WEST SUSSEX COUNTY COUNCIL CONSULTATION

TO:	<u>Arun</u> District Council <u>FAO:</u> Michael Eastham
FROM:	<u>WSCC</u> - Highways Authority: Tim Townsend
DATE:	19 October 2020
LOCATION:	Land south of Ford Lane East of North End Road <u>Yapton</u> <u>BN18 0DS</u>
SUBJECT:	<u>Y/105/20/DOC</u> Approval of details reserved by condition imposed under Y/80/16/OUT relating to condition 10- Construction Method Statement (CMP).
DATE OF SITE VISIT:	<u>n/a</u> for this specific application (site visited at outline stage)
RECOMMENDATION:	More Information Required
S106 CONTRIBUTION TOTAL:	SEE OUTLINE PLANNING PERMISSION

This is the WSCC County Highway Authority (CHA) response to the above planning application for approval of details reserved by condition imposed under Y/80/16/OUT relating to condition 10 - Construction Method Statement (CMP).

FORD LANE YARDON
CONSTRUCTION PHASE PLAN

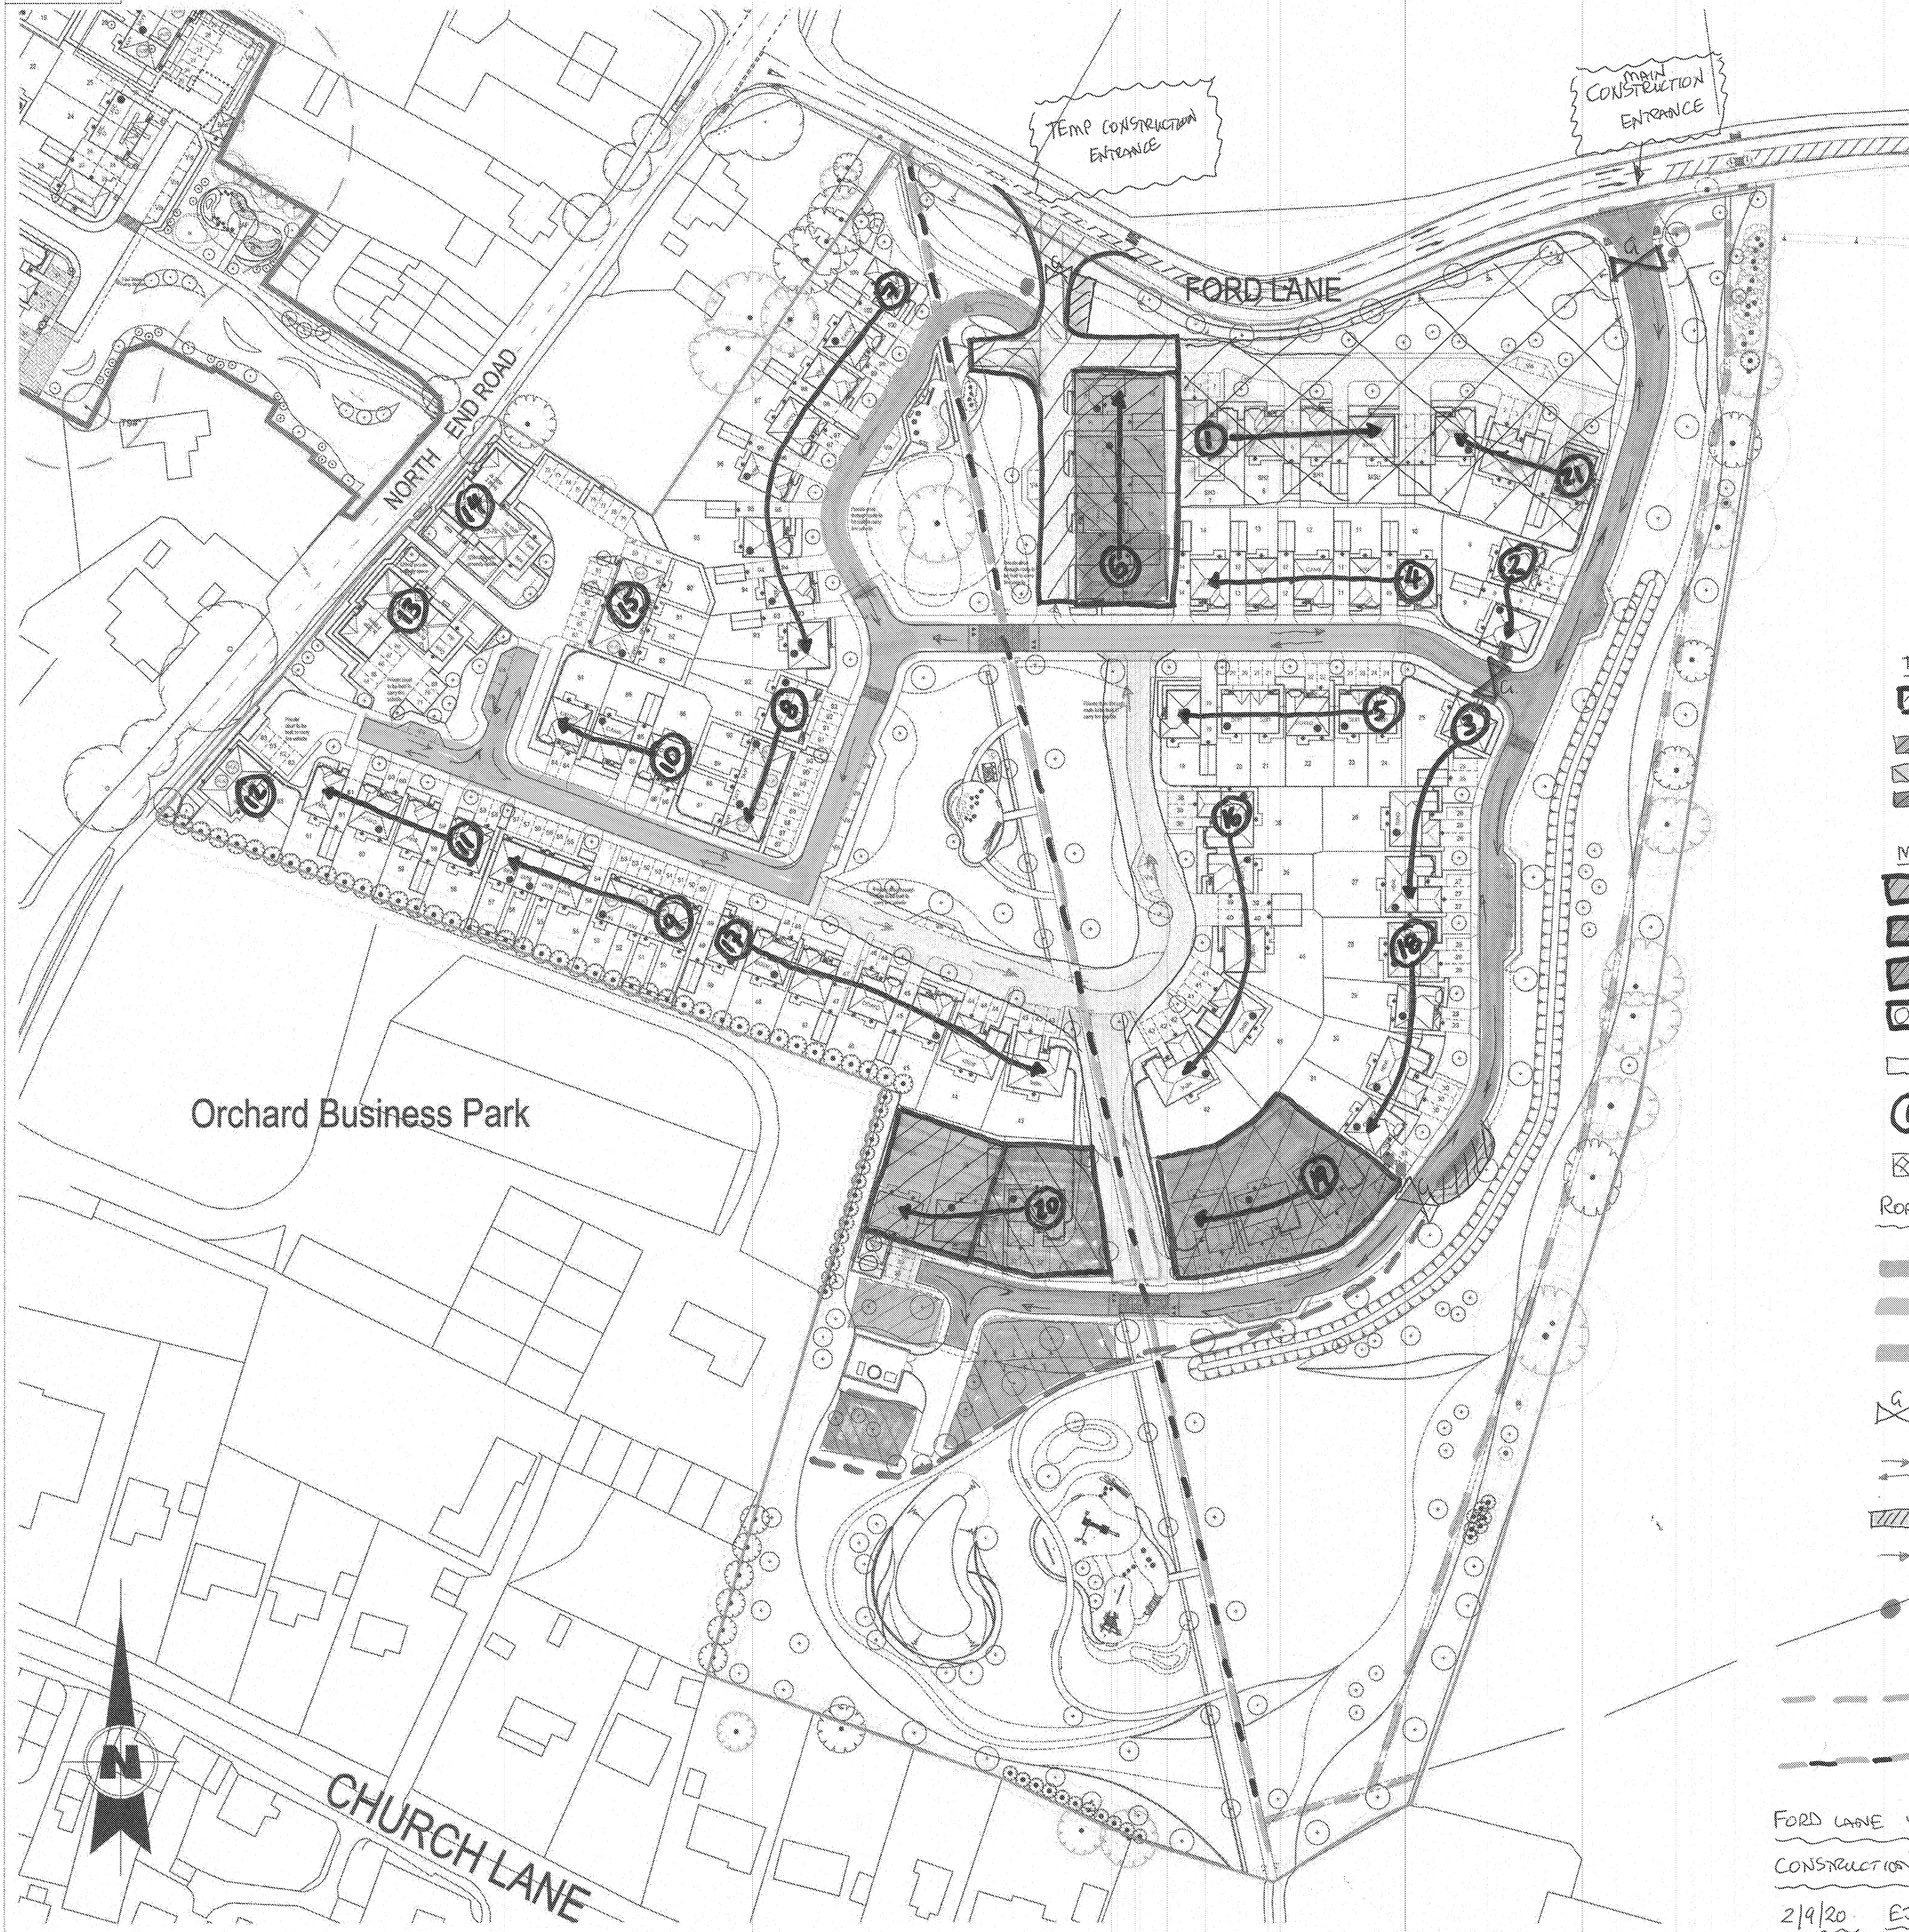
The CMP refers to a temporary site entrance and includes a plan showing the indicative location of it. However, no detailed plans are provided nor is it stated why this access is required. As such, the application should provide this additional information, including a Stage 1 Road Safety Audit plus any other supporting information, including the duration of time that the temporary access is required for.

A site compound plan should also be provided.
